Schedule of Additional Minor modifications (refer to numbered revision clouds on the drawings)

ar-1209 B05

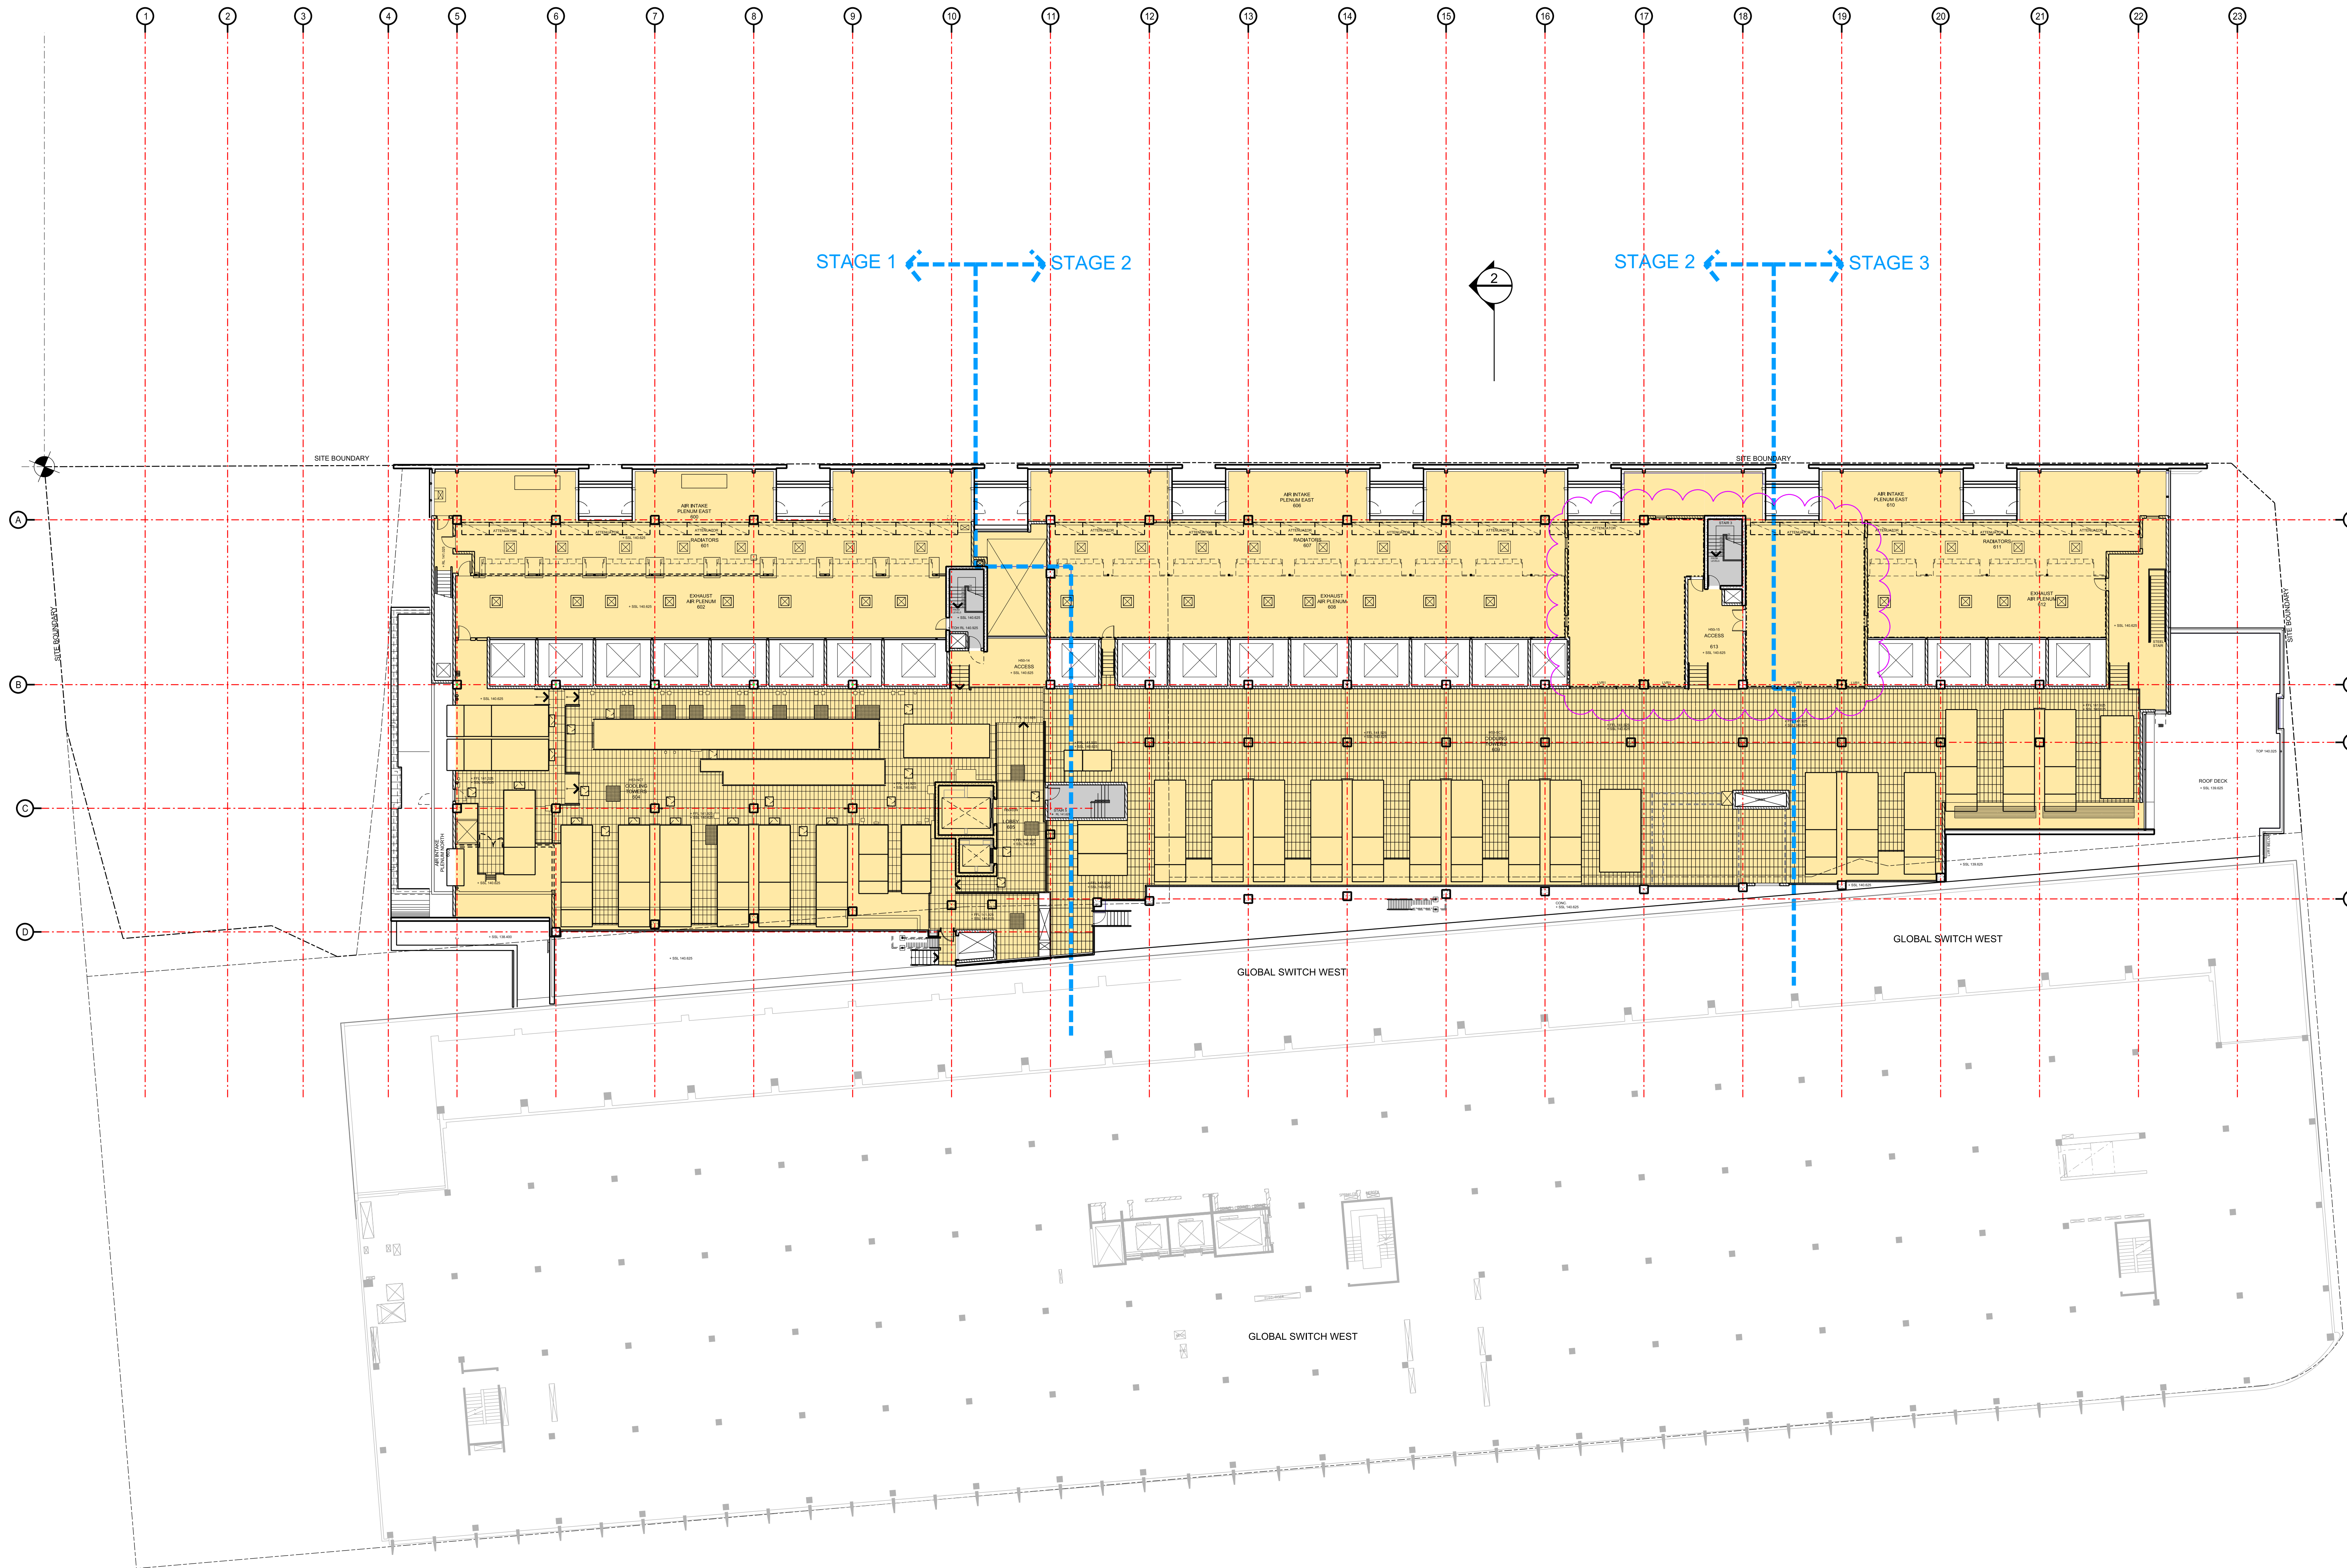
11	Second	Relocated position for Stage 1 BMS room.
	12	Second	Stage 1 BMS cupboard in lift lobby deleted.
	13	Second	Extended area of cloud indicating relocation of switch rooms & technical area already described in the current planning modification submission & already included in revised area calculations
ar--1206	14	Third	Riser duct deleted as no longer required.
	15	Third	Services cupboards deleted as no longer required.
	16	Third	Extended area of cloud indicating relocation of switch rooms & technical area already described in the current planning modification submission & already included in area revised calculations.
ar--1207	17	Fourth	Riser duct and air-conditioning plant room deleted as no longer required.
ar--1208	18	Fifth	Riser duct deleted as no longer required.
	19	Fifth	Change in size of UPS switch rooms in Stage 3 area
	20	Fifth	Air intake plenum in Stage 3 area extended
ar--1209	21	Sixth	Riser duct added.

22	Sixth	Stair wall in Stage 3 moved.
ar--1211	23	Roof	Grid mesh roof area amended.
	24	Roof	Position of intakes to Stage 3 cooling towers amended.
ar--2501	25	East elevation	Amendment of incorrectly labelled stone facade finishes – the majority of stonework on this elevation is sandstone as depicted in the perspective images submitted with the original application. Note: ar-2500 south elevation needs no correction.

ar--1203 B07

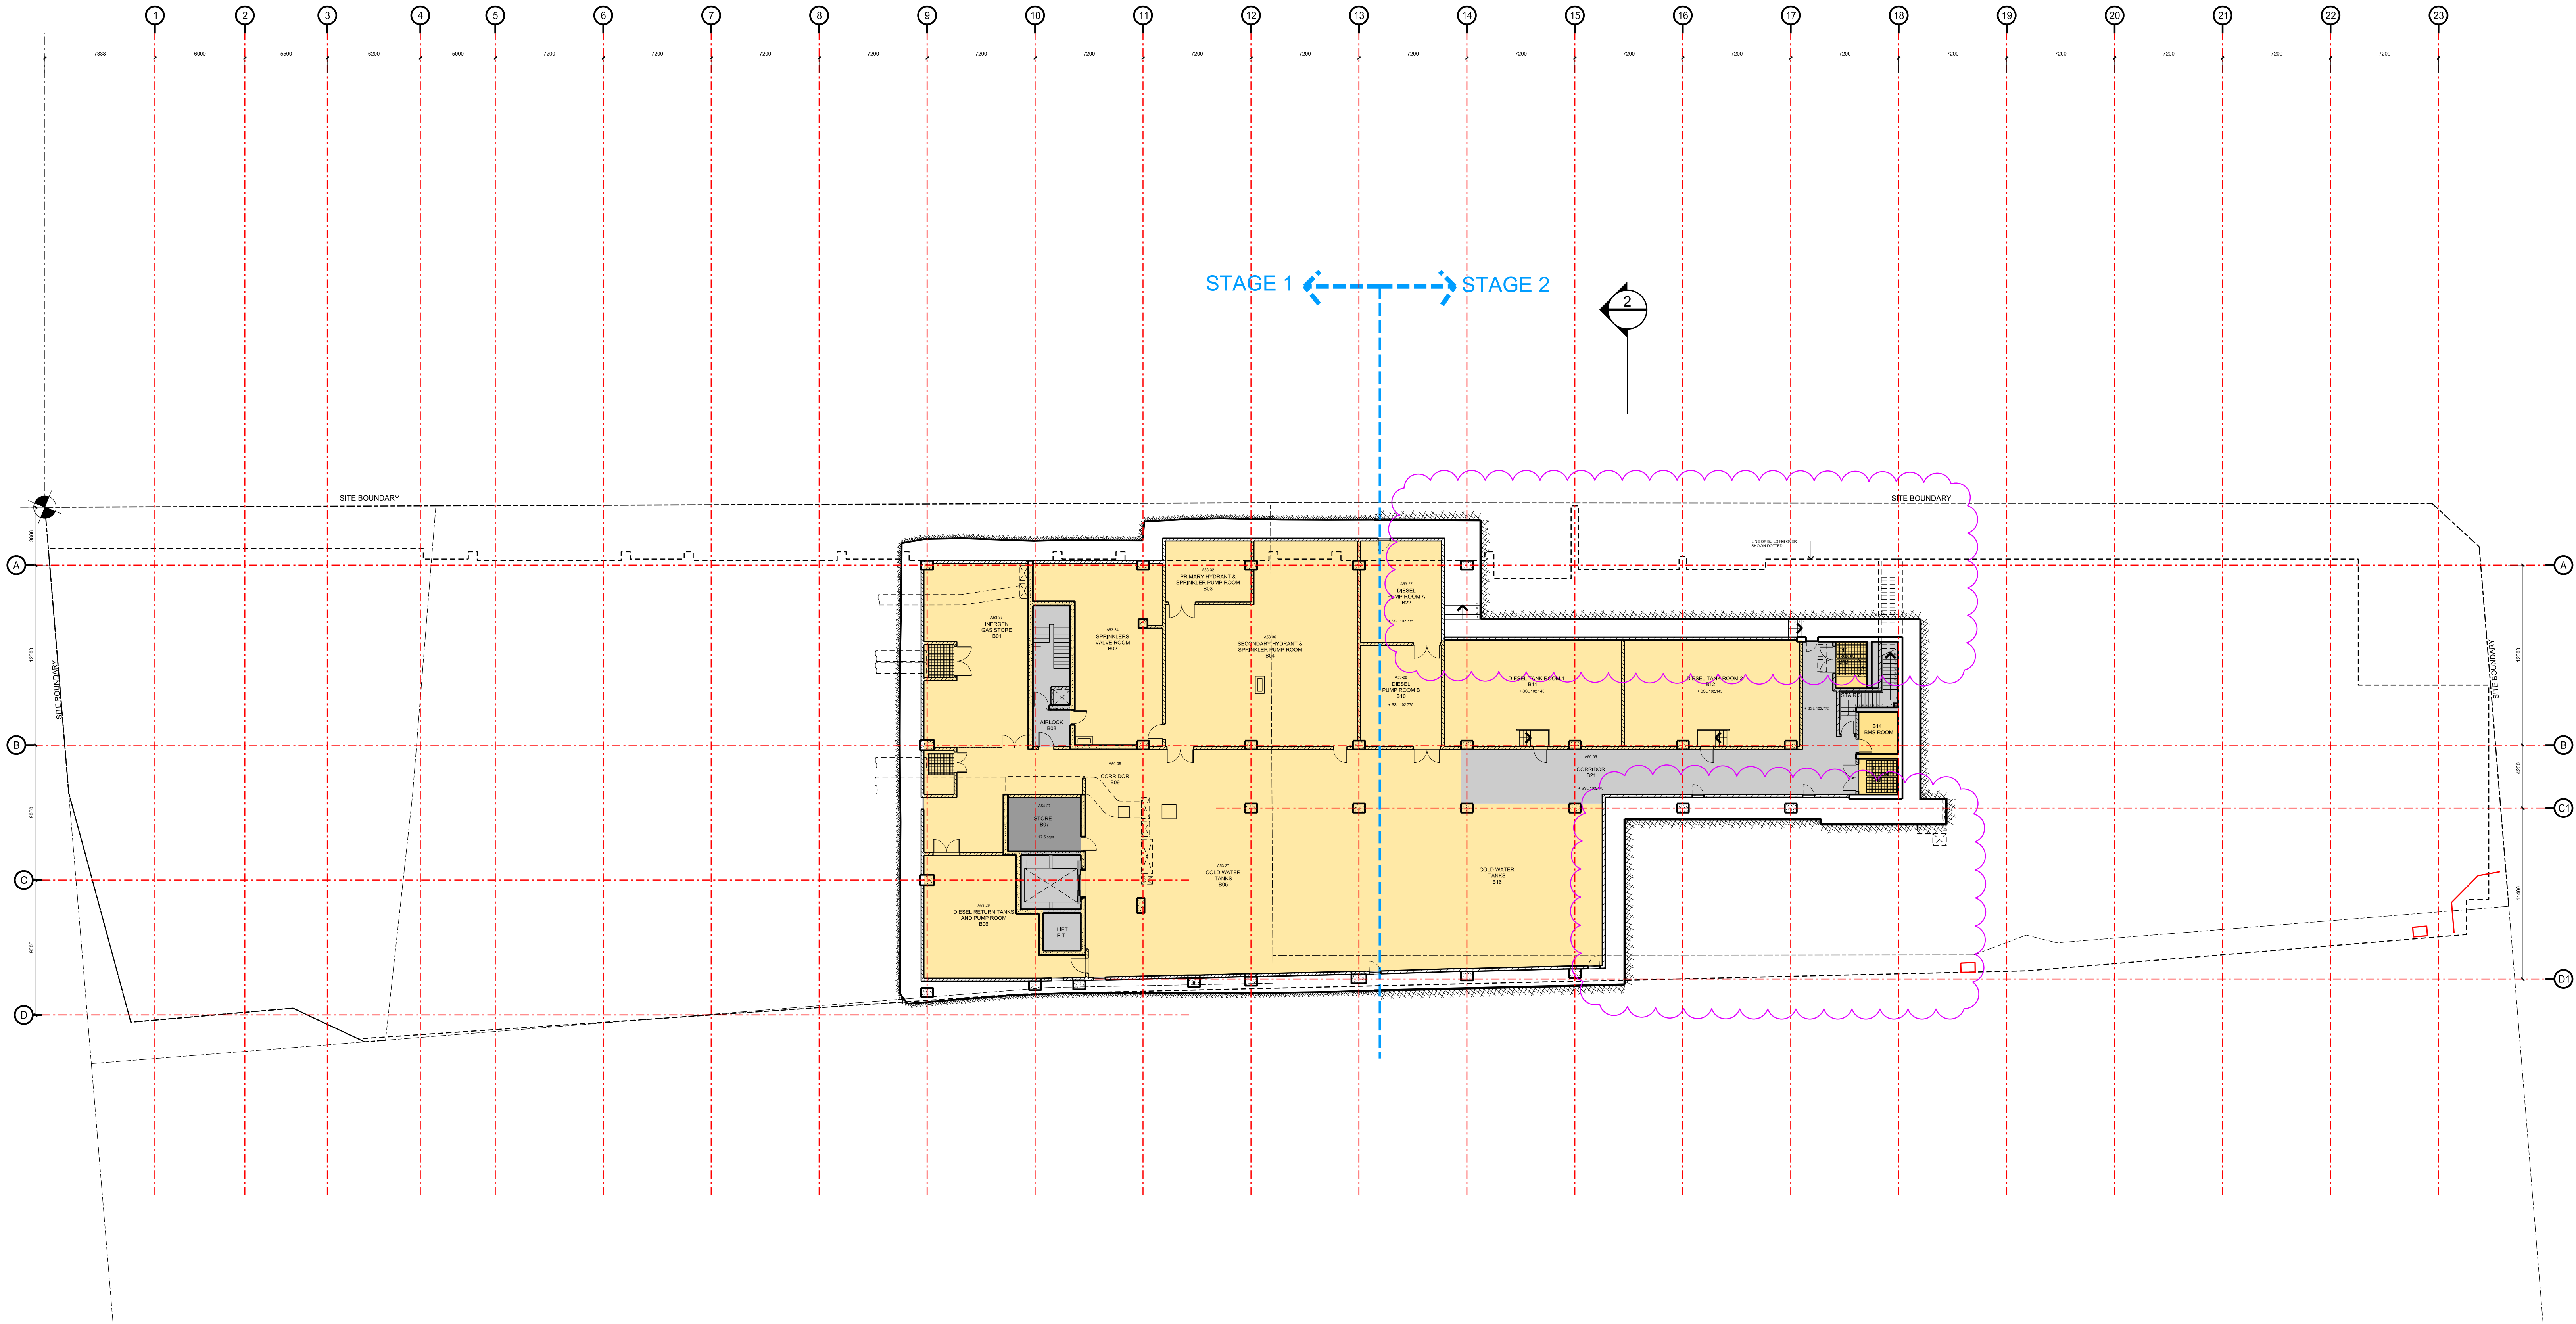
Drawing number	Revision cloud number	Floor level	Description of amendment
ar--1203	1	Ground	Stage 1 BMS/Security room relocated and area added to Meet Me Room
	2	Ground	Pit room within the Stage 1 Meet Me Room deleted as not required.
	3	Ground	Fire Room not longer needs to be increased in size in Stage 2
	4	Ground	Stage 1 BMS/Security room relocated to the end of Lift lobby
	5	Ground	Proposed Stage 3 Meet Me Room relocated to Stage 2 area between grids 16 and 17 (already covered in the submission).
ar--1204	6	First	Stage 1 BMS/Security room relocated from Lift lobby
	7	First	Stage 1 BMS/Security cupboard in lift lobby relocated (refer to item 6)
	8	First	Extended area of cloud indicating relocation of switch rooms & technical area already described in the current planning modification submission & already included in revised area calculations
ar--1205	9	Second	Stage 1 BMS room relocated
	10	Second	Riser duct deleted as no longer required.
